This comment in respect of a number of items covered by deadline1.

Heather Fox

18.08.25

Comments ref. the following where OE is One Earth, EA is Environment Agency

Figure 7.5: Functional Floodplain
(Flood Zone 3b)

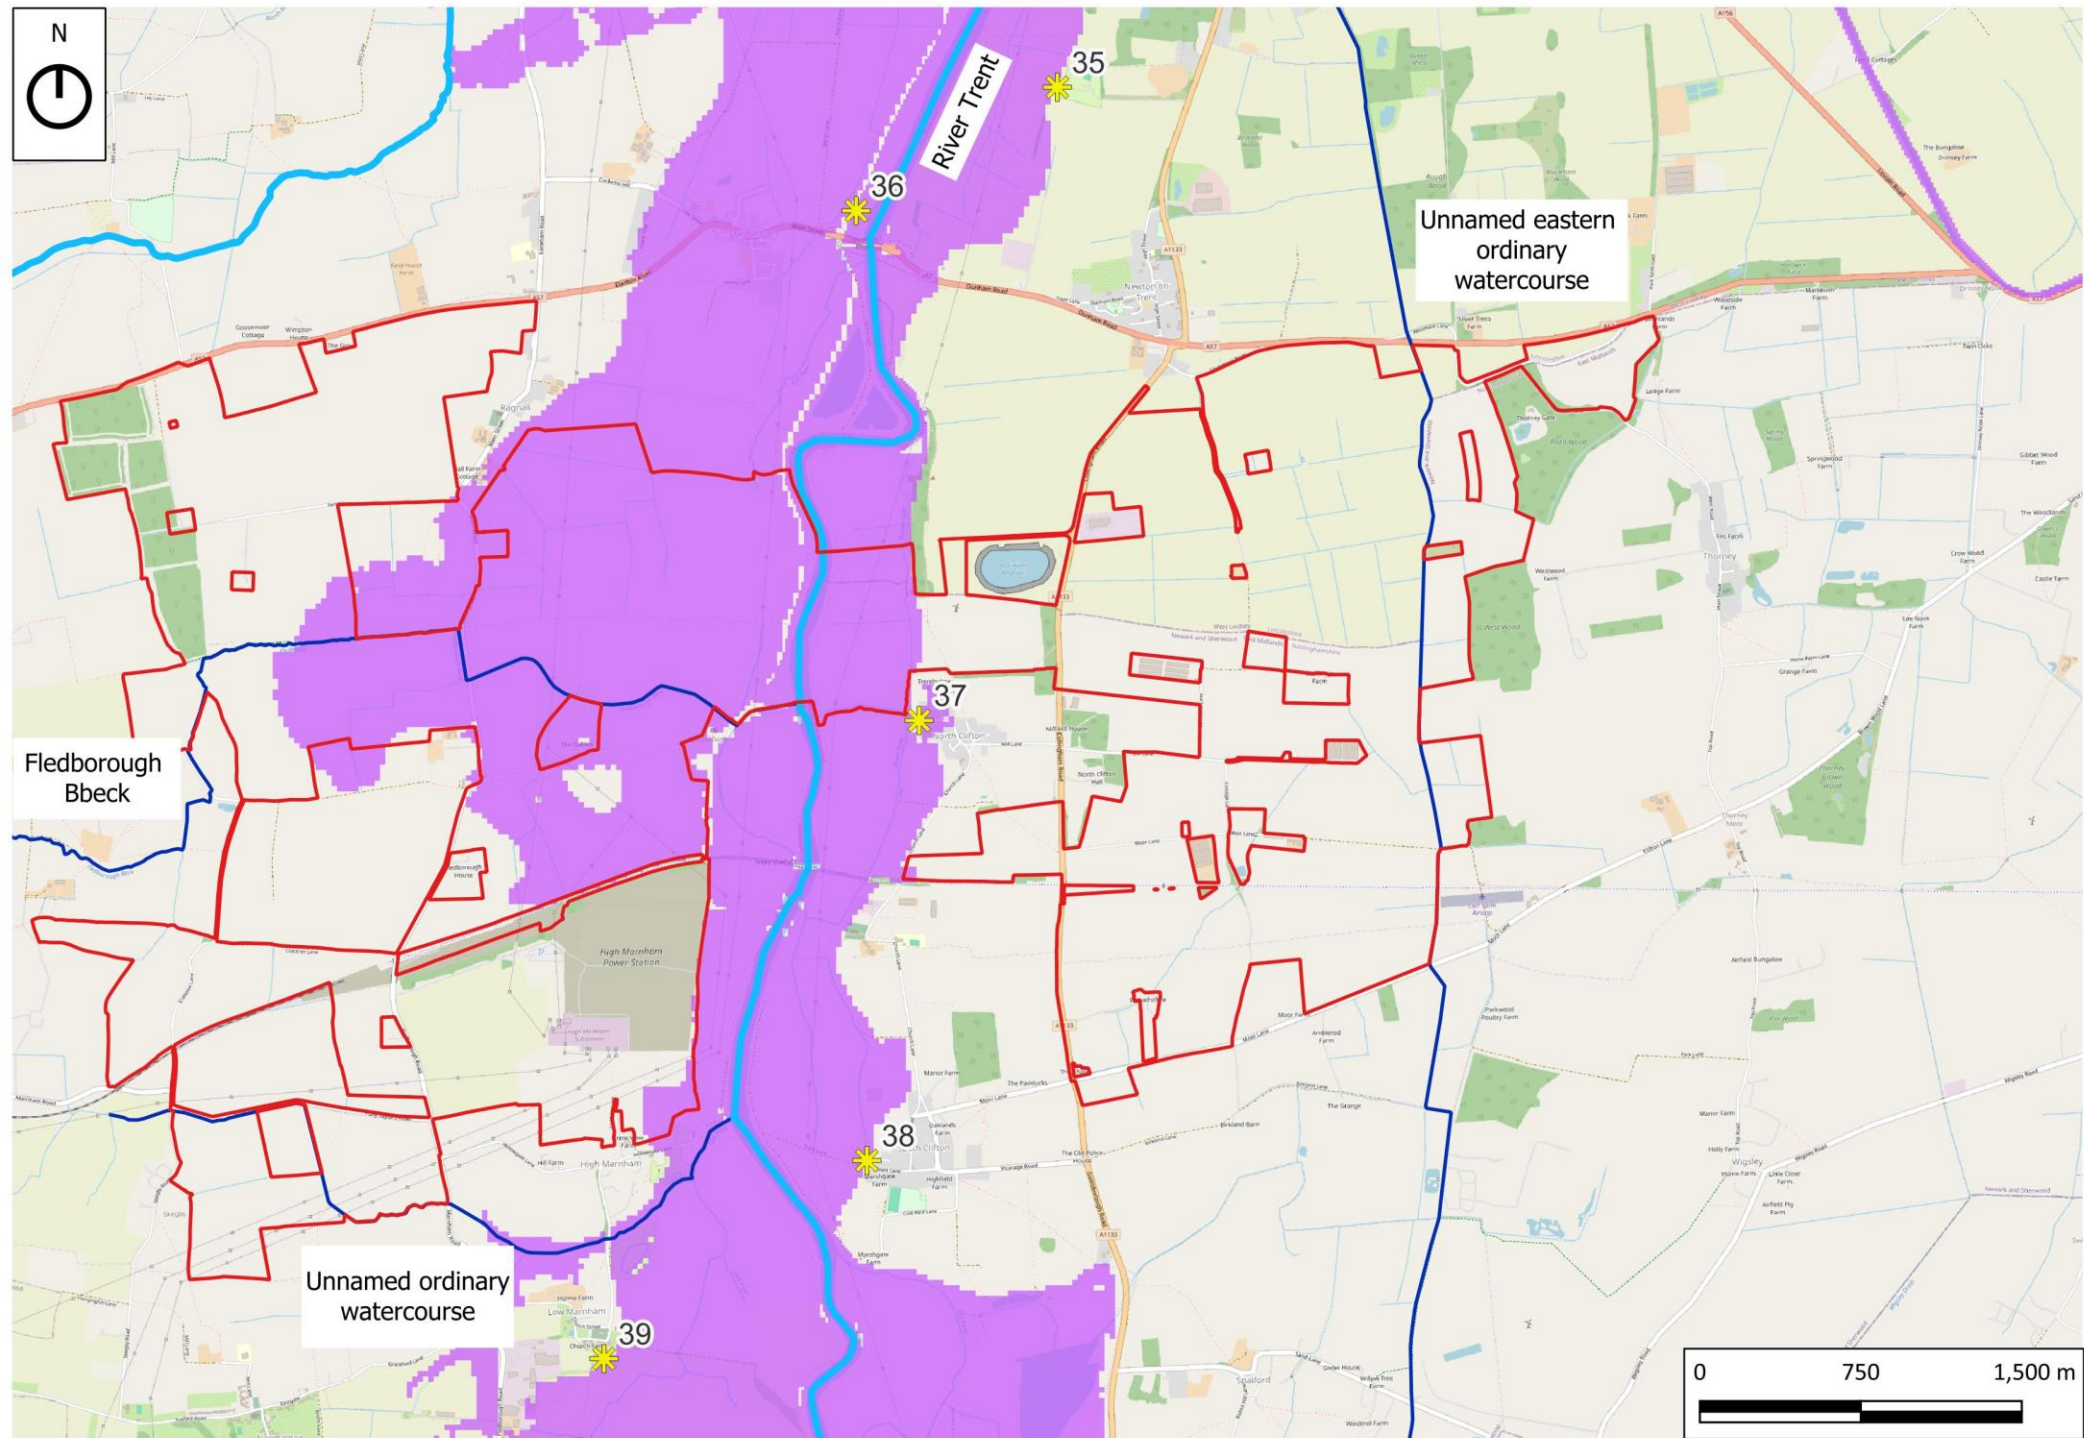
I have tried to discover who is responsible for delineating the Functional Floodplain where the Trent is tidally influenced. Without accurate measurements there is room for manoeuvre. I have been passed from the EA to NCC back to the EA then to NSDC from whom I am currently awaiting a response. When I look at the NSDC's SFRA it states ' The river Trent to the north of Cromwell Weir is tidally influenced and does not have a modelled functional floodplain outline. Where potential development falls within the flood zone 3a further modelling should be undertaken on a site-specific basis to determine the extent of the functional floodplain '. Has this been done? Otherwise, how has the applicant portrayed accurately the functional floodplain on Map Fig. 7.5 EN010159/APP/6.20?
